**RE: ATLISSIAN CENTRAL
BCA/ACCESS/DDA COMPLIANCE STATEMENT FOR STATE SIGNIFICANT DEVELOPMENT
APPLICATION**

Blackett Maguire + Goldsmith Pty Ltd have been commissioned by Atlassian (the applicant) to prepare this report in accordance with the technical requirements of the secretary's Environmental Assessment Requirements (SEAR's) and in support of the SSD-10405 for a commercial and hotel development above the Former Inwards Parcel Shed at 8-10 Lee Street, Haymarket

DRAWING

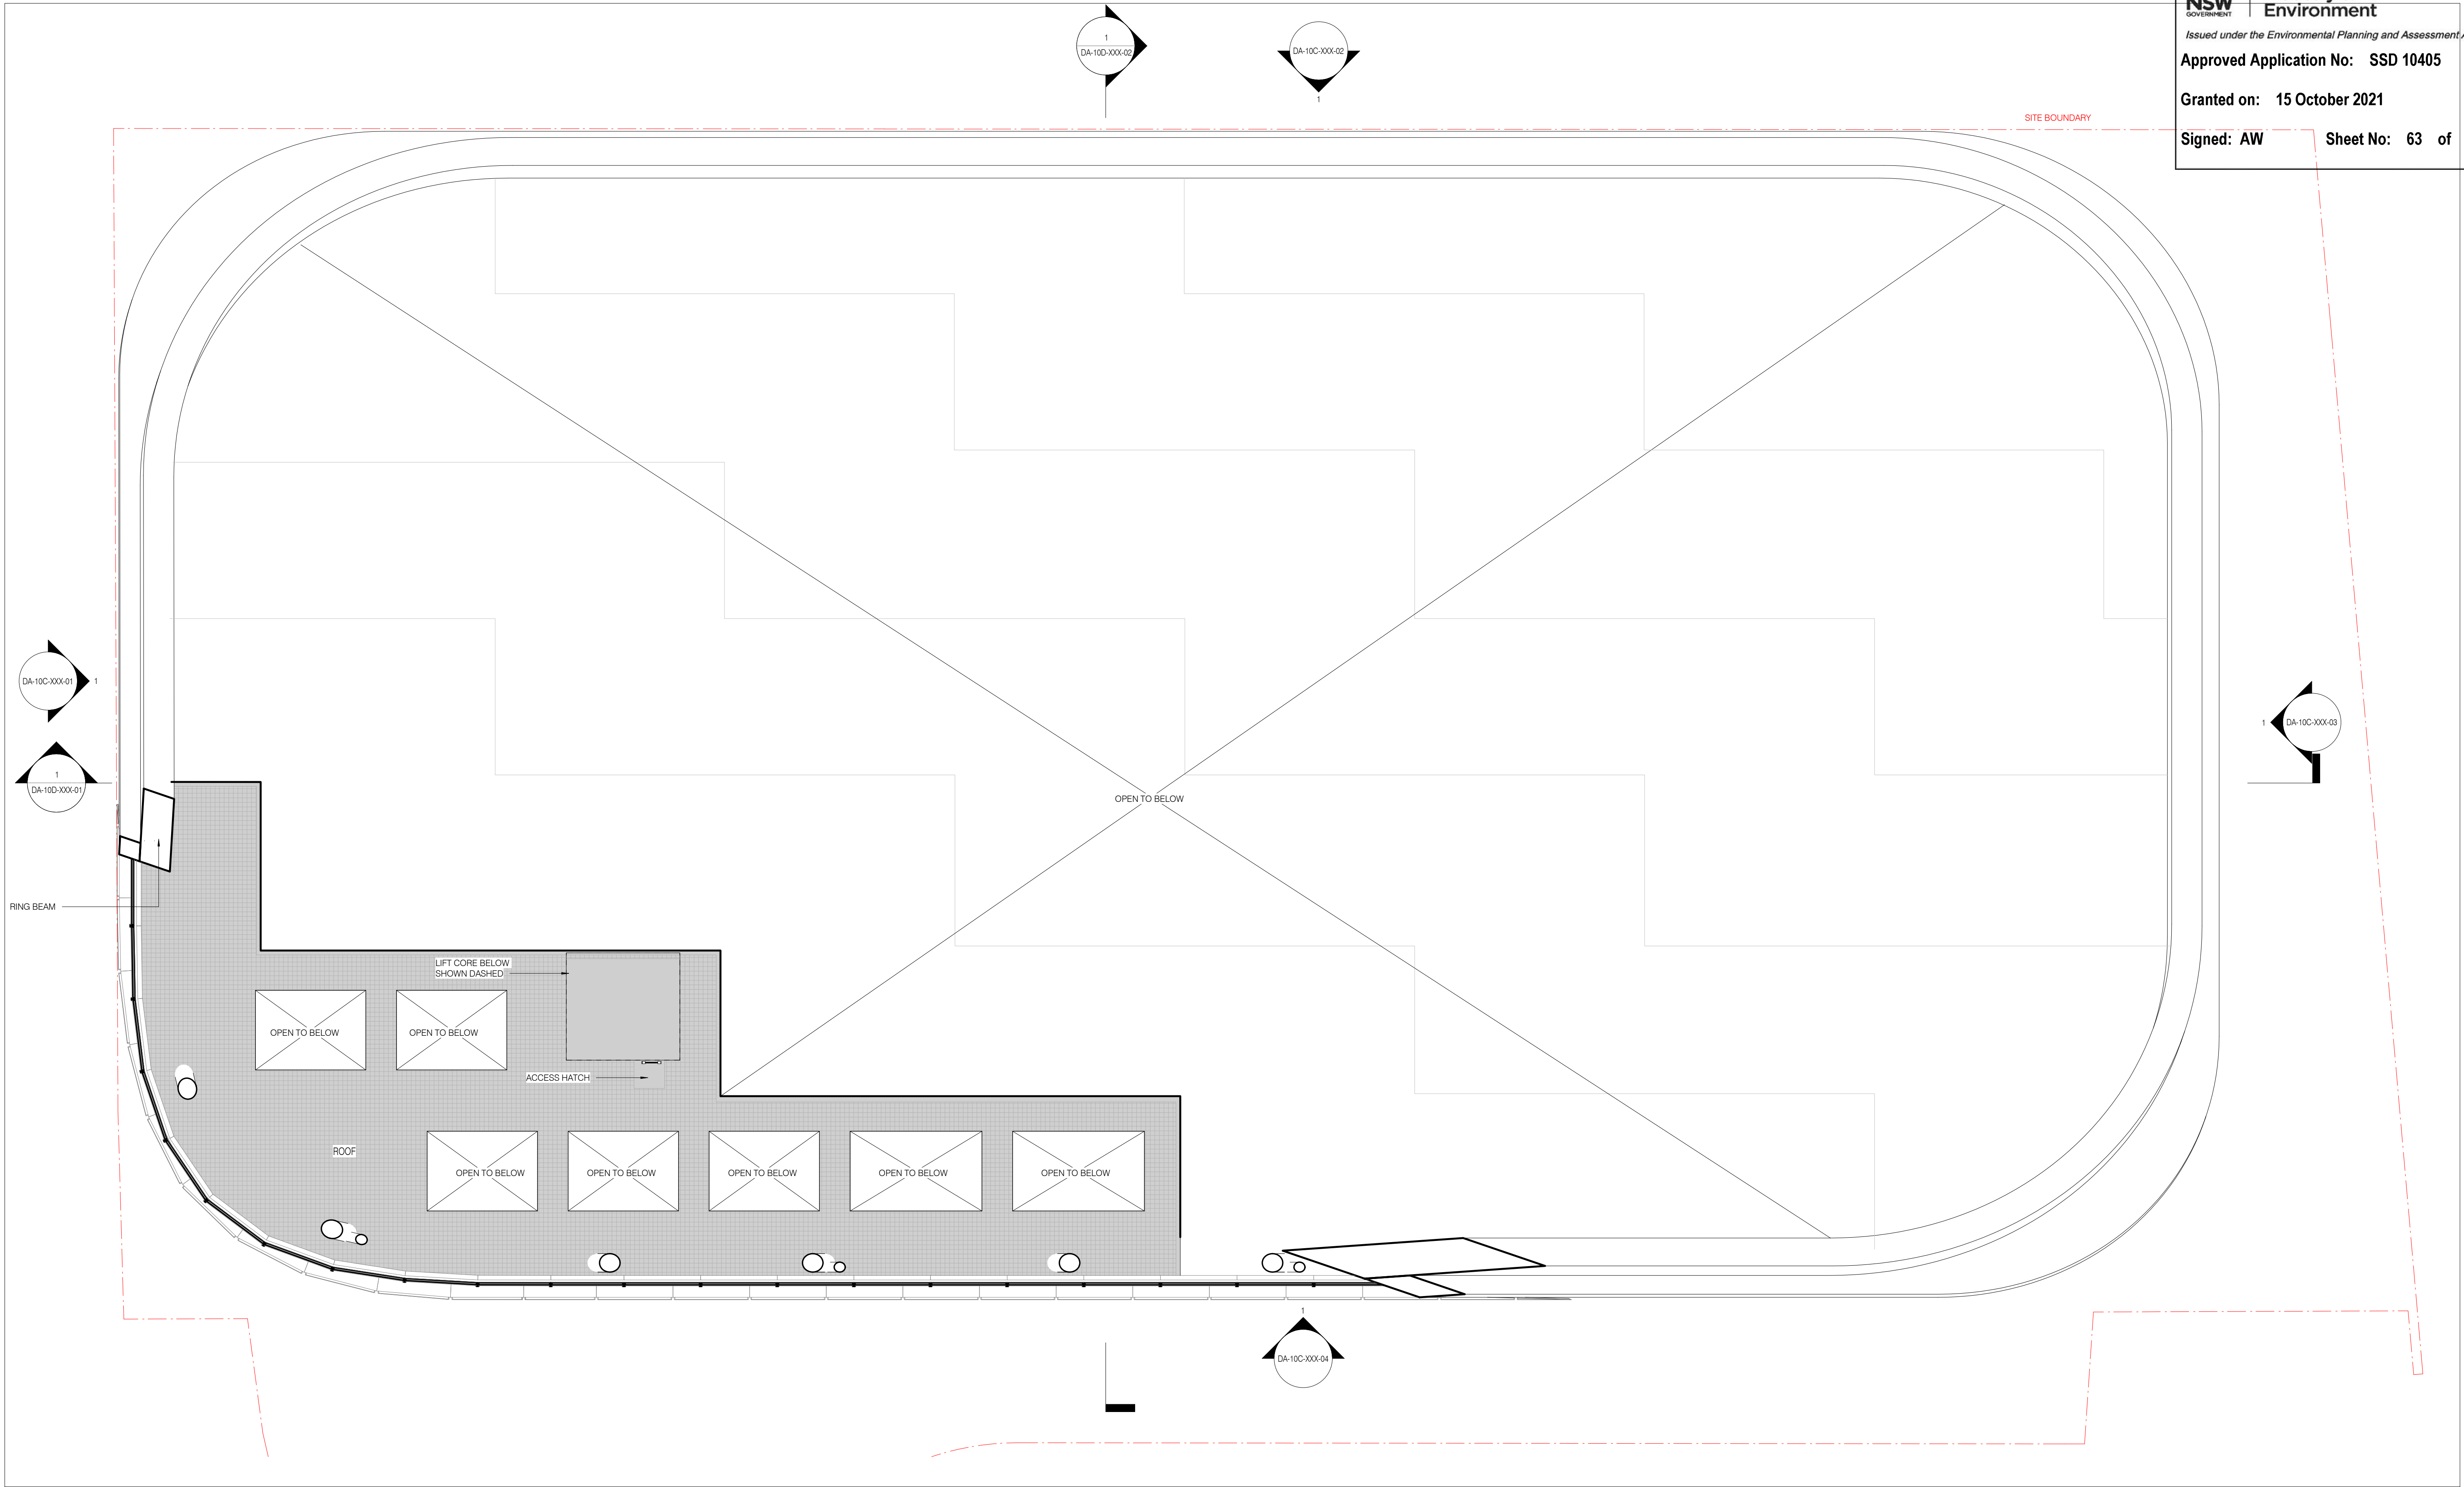
| 7. | D1.2 | <p>Only one exit is provided to the following areas in a building over 25m;</p> <ul style="list-style-type: none"> + Lower ground retail tenancies + Level 38 and 39 Plant rooms. |
| 8. | D1.3 | To have a non-fire isolated exit in lieu of a fire isolated exit serve and connect level 37-39 plant room areas. |
| 9. | D1.4 | <p>Exit travel distances in the order of; <i>(to be refined)</i></p> <ul style="list-style-type: none"> + Class 5,7,8 BOH basement areas: 28m to point of choice in lieu of 20m. + Class 3 Level 6: 12m to point of choice in lieu of 6m. + Class 5 office levels: 28m to point of choice in lieu of 20m + Class 5 office levels: 60m to nearest exit in lieu of 40m. + Class 5 ancillary plant areas level 37-39: 40m to point of choice in lieu of 20. |
